A417 Missing Link DCO

Joint Councils comments on National Highways
Deadline 2 submission

Gloucestershire County Council, Cotswold District Council,
Tewkesbury Borough Council

2 February 2022

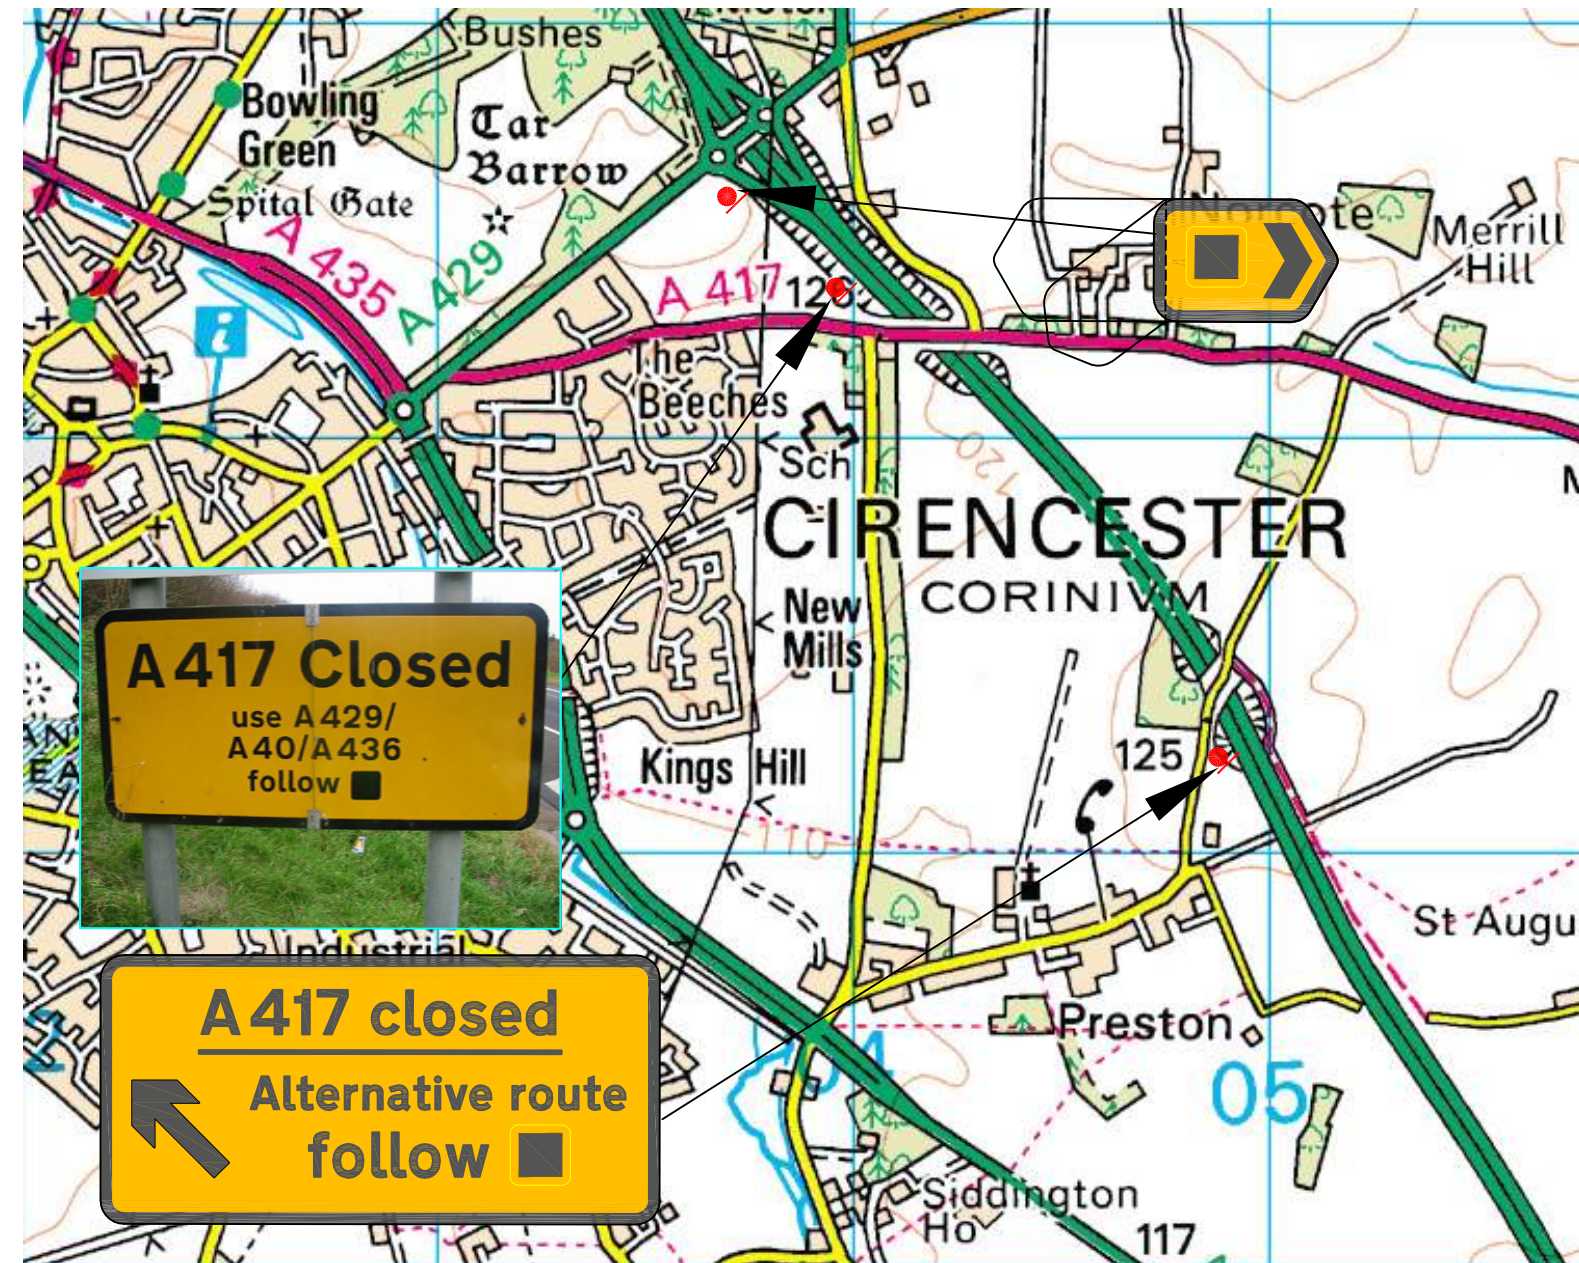
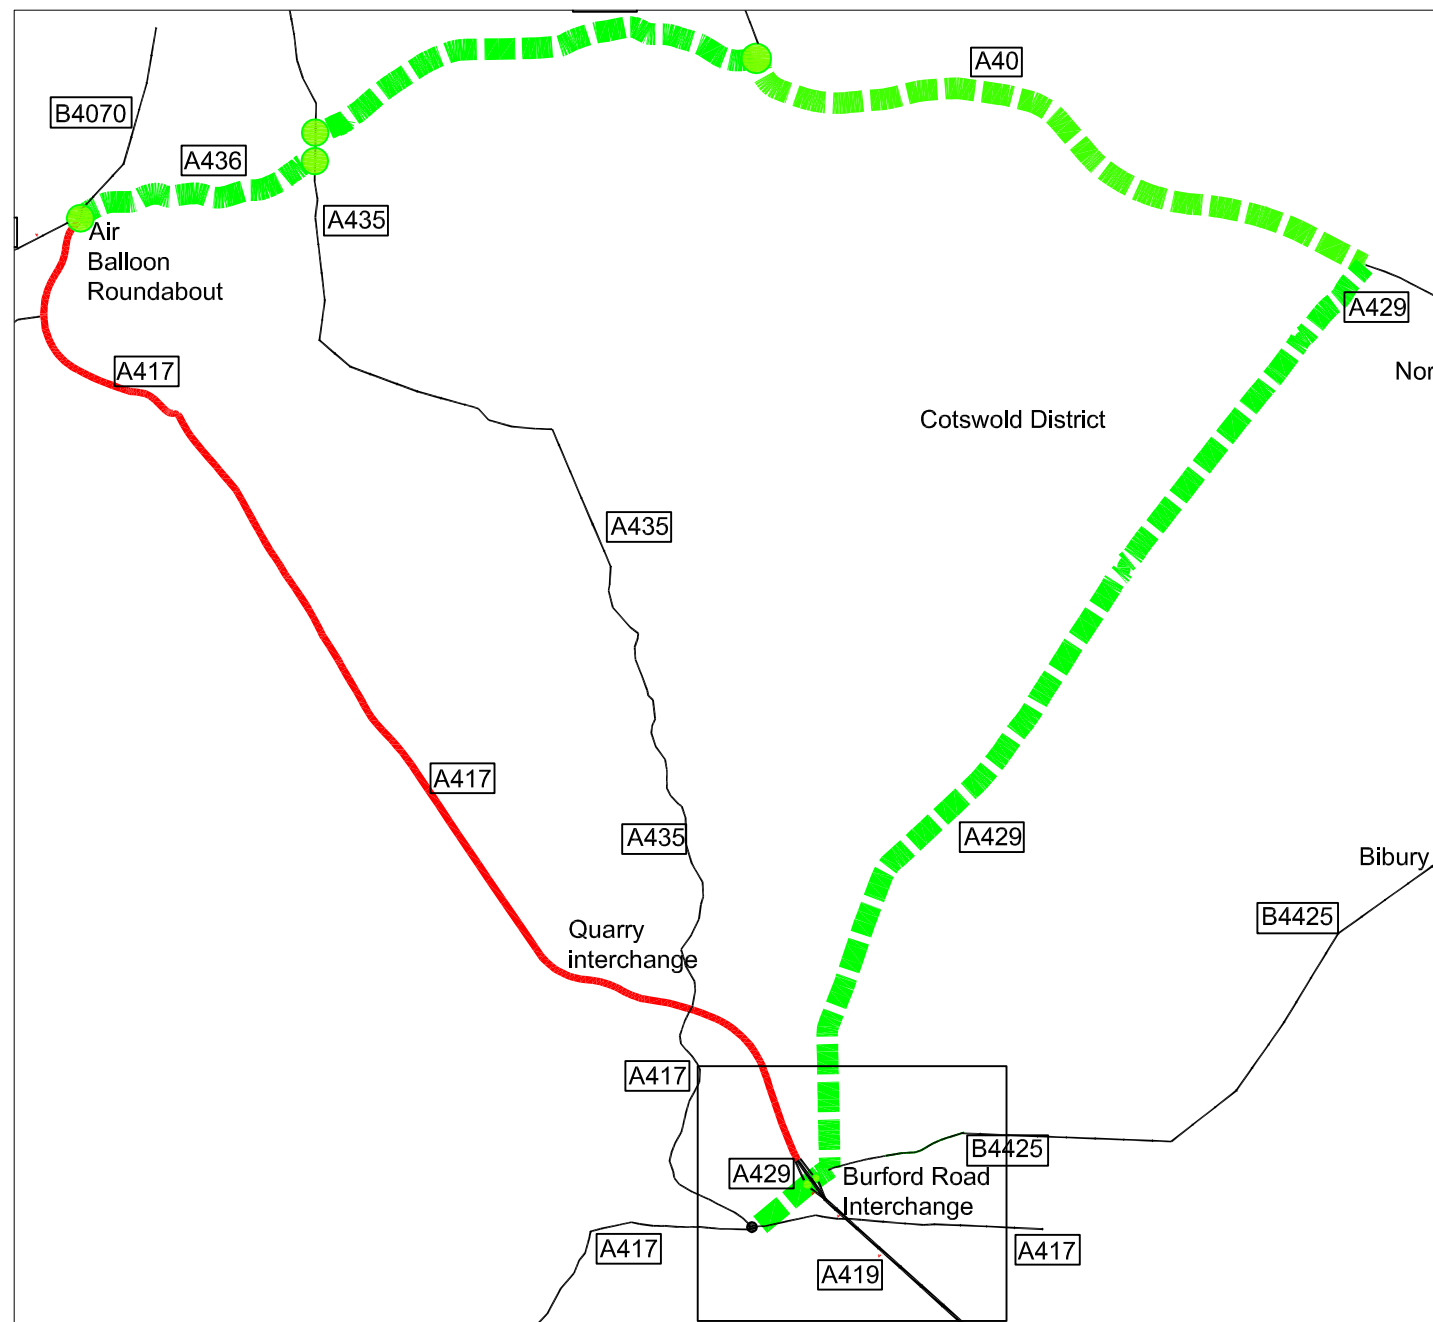
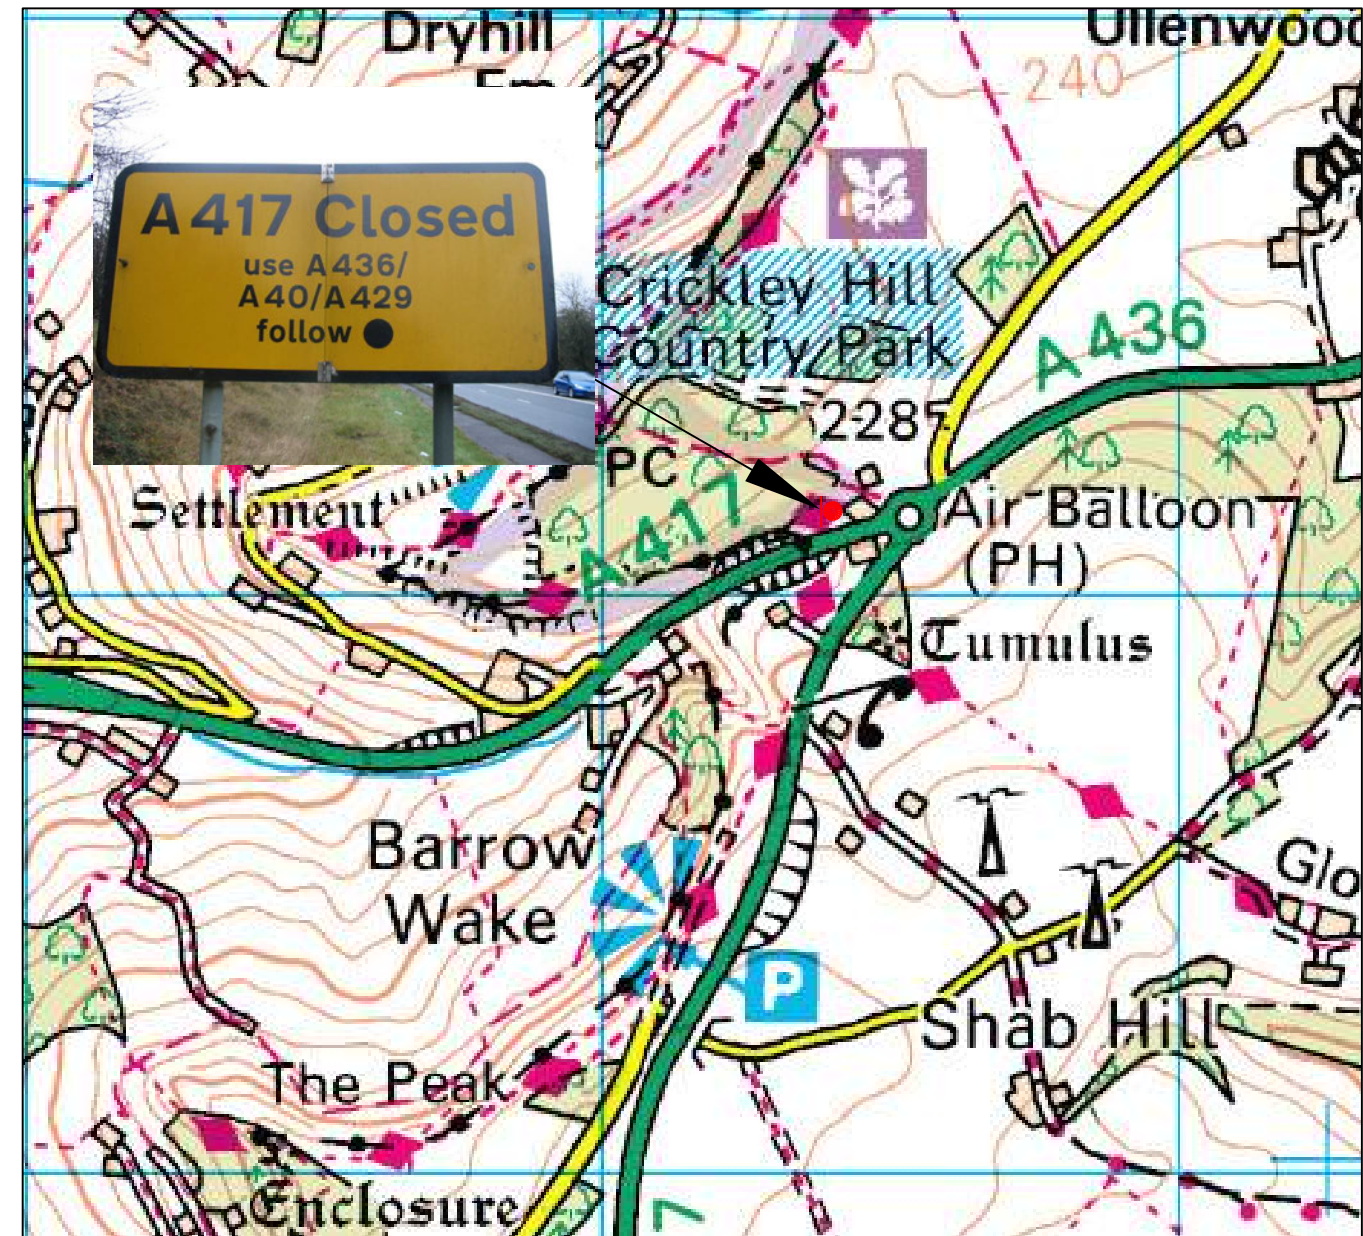
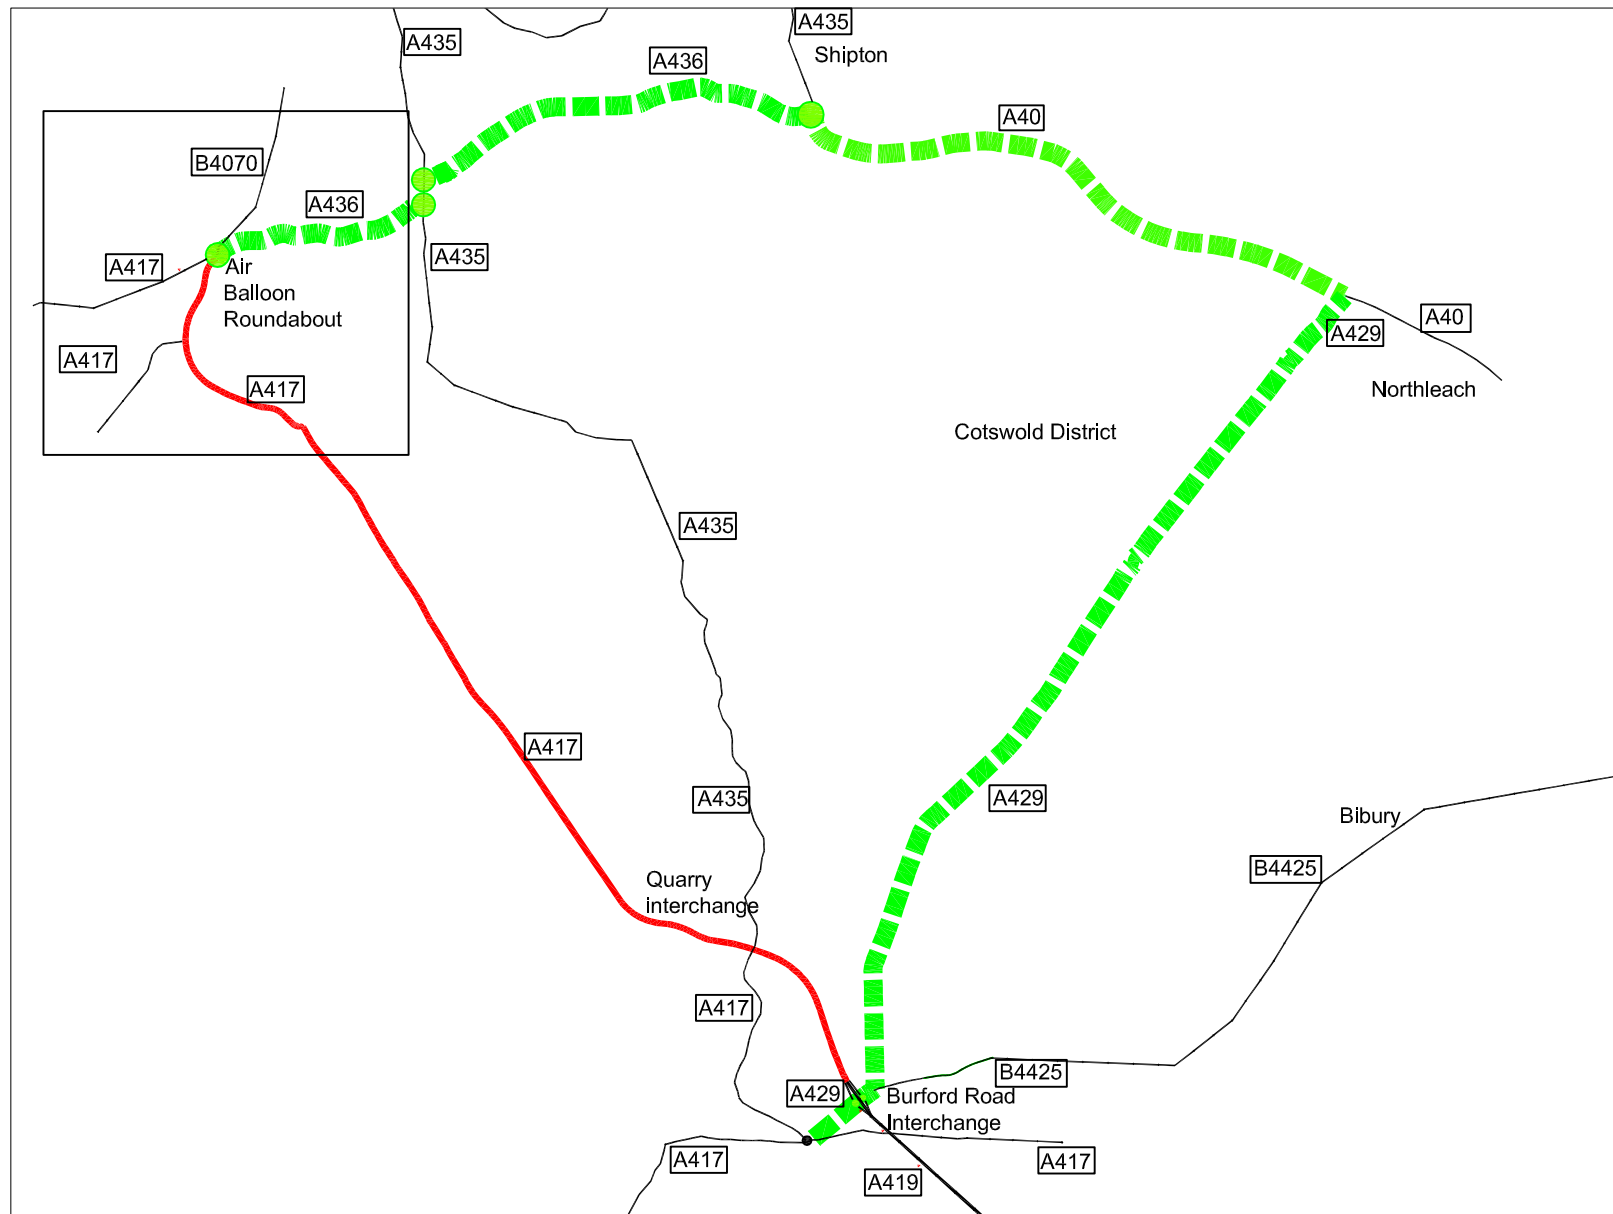
2.1.14	6.4 (Rev 1) Appendix 2.1 EMP Annex B Construction Traffic Management Plan (Tracked)	App F		<p>The two diversion routes set out in the CTMP are aimed primarily at dealing with rerouting strategic traffic movements during closures on the A417. GCC expects that more locally based traffic would divert onto nearby 'shorter' alternative rat-run routes. It is also likely that similar local diversions (traffic reassignment) will occur, although to a lesser extent, when temporary mitigation measures are in place at limited times during the 33 month construction works period e.g. those times when there are 40mph speed limits and restricted lane widths, 40mph speed limits and single lane widths, and 40mph speed limits and contraflow running. For confirmation of the likely impacts, it is therefore recommended that Highways England carry out indicative traffic modelling scenarios for the 2026 year of opening to assess/quantify local network traffic conditions during the scheme construction period when short-term A417 section closures, speed restrictions and lane width reductions are planned to be in operation.</p> <p>The CTMP should set out the details of appropriate mitigation measures to address any identified issues on local roads, for example details of a temporary signage strategy to be installed along the A435 to deter diverted traffic from using High Cross and the lanes through Cowley and Stockwell to access the A417.</p>
